**KIRKLEES METROPOLITAN COUNCIL
INVESTMENT & REGENERATION SERVICE**

**DELEGATED DECISION FOR DISCHARGE OF CONDITION A.4 -
NOTIFICATION OF A PROPOSED ENLARGEMENT TO DWELLINGHOUSE**

Reference no.	2020/HH/93180/E
Site Address	53, Broad Street, Scout Hill, Dewsbury, WF13 3RT
Description	The proposal is for erection of single storey rear extension. The extension projects 4.5m beyond the rear wall of the original dwellinghouse. The maximum height of the extension is 3.15m, the height of the eaves of the extension is 2.8m
Recommending Officer	Tom Hunt

BLOCK PLAN
SCALE 1:500

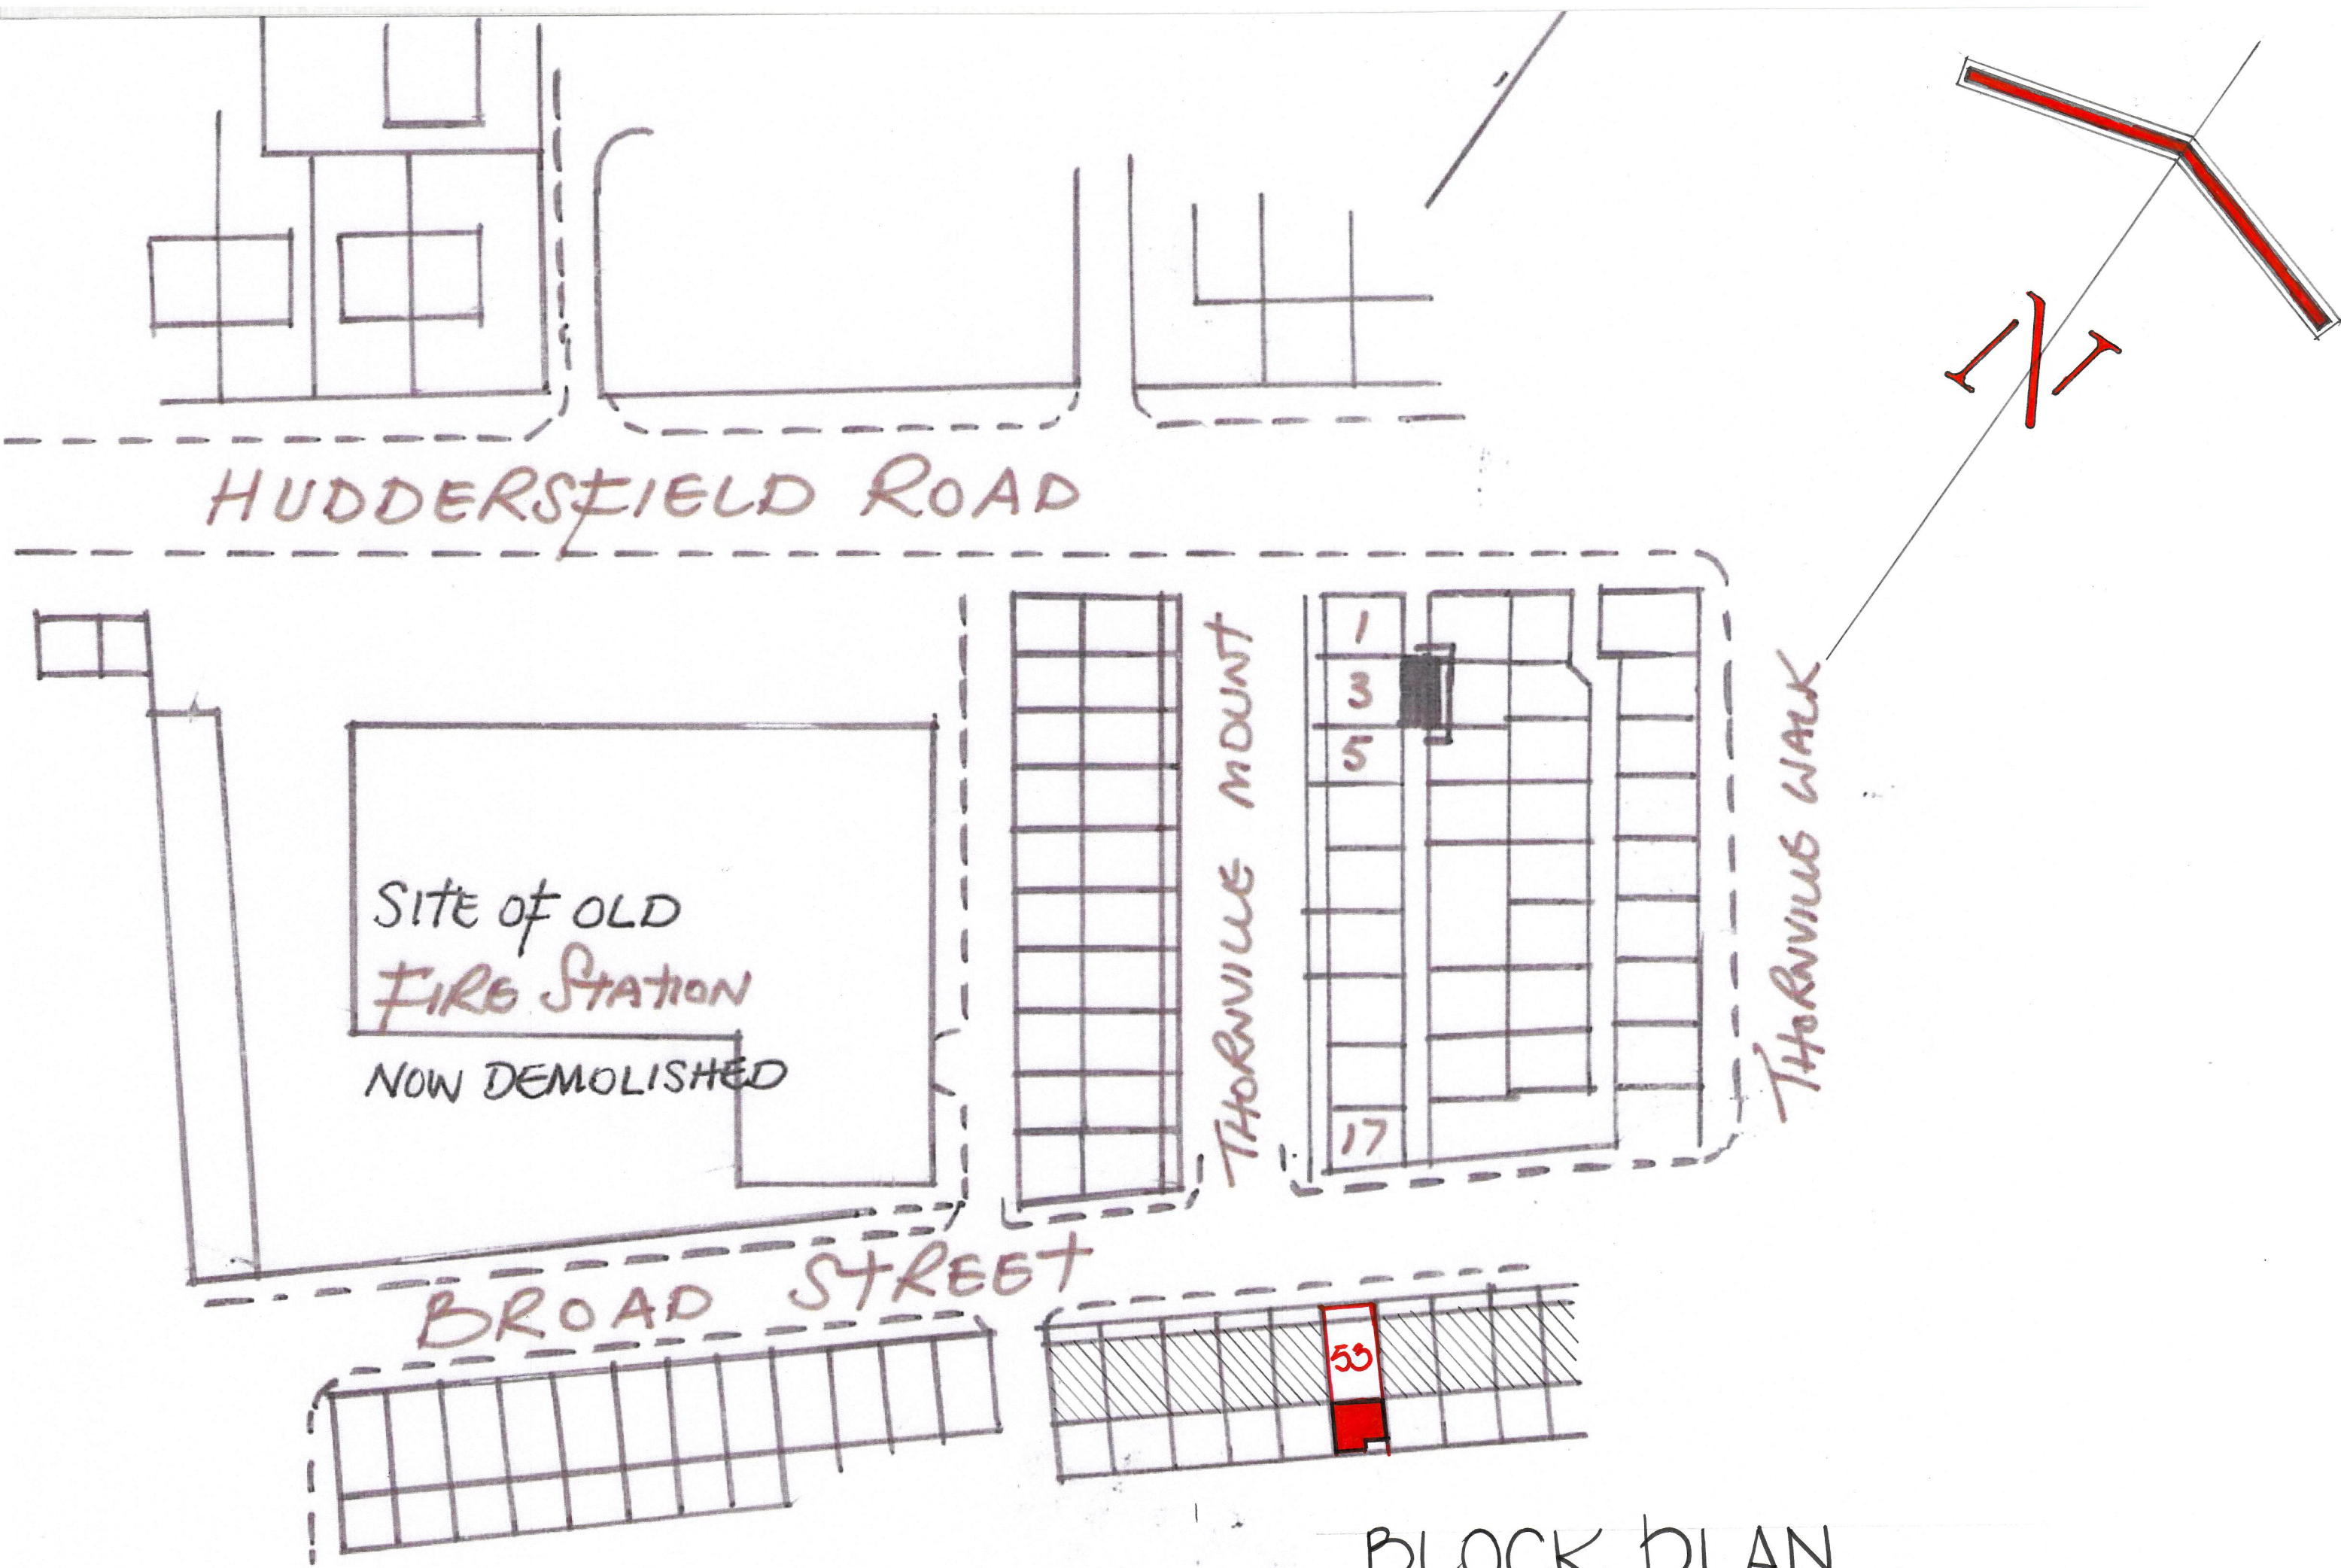
The proposed extension is a single storey extension adjoined to a two storey dwellinghouse to create a larger kitchen/dining room. This proposal seeks to build on more than 50% of the curtilage of the dwellinghouse in the rear yard (4.5 metres by 4.5 metres) to leave an area of approximately 2.25 metres by 1 metre of unbuilt on ground.

The criterion stated at paragraph A.1 (b) of Class A states that development is not permitted if *“as a result of the works, the total area of ground covered by buildings within the curtilage of the dwellinghouse (other than the original dwellinghouse) would exceed 50% of the total area of the curtilage (excluding the ground area of the original dwellinghouse)”*.

By reason of this extension exceeding the limitations set out in sub-paragraph (b) and therefore **cannot** be considered to benefit from a general planning permission by virtue of Part 1, Class A of Schedule 2 of the Town and Country Planning (General Permitted Development)(England) Order 2015 (as amended).
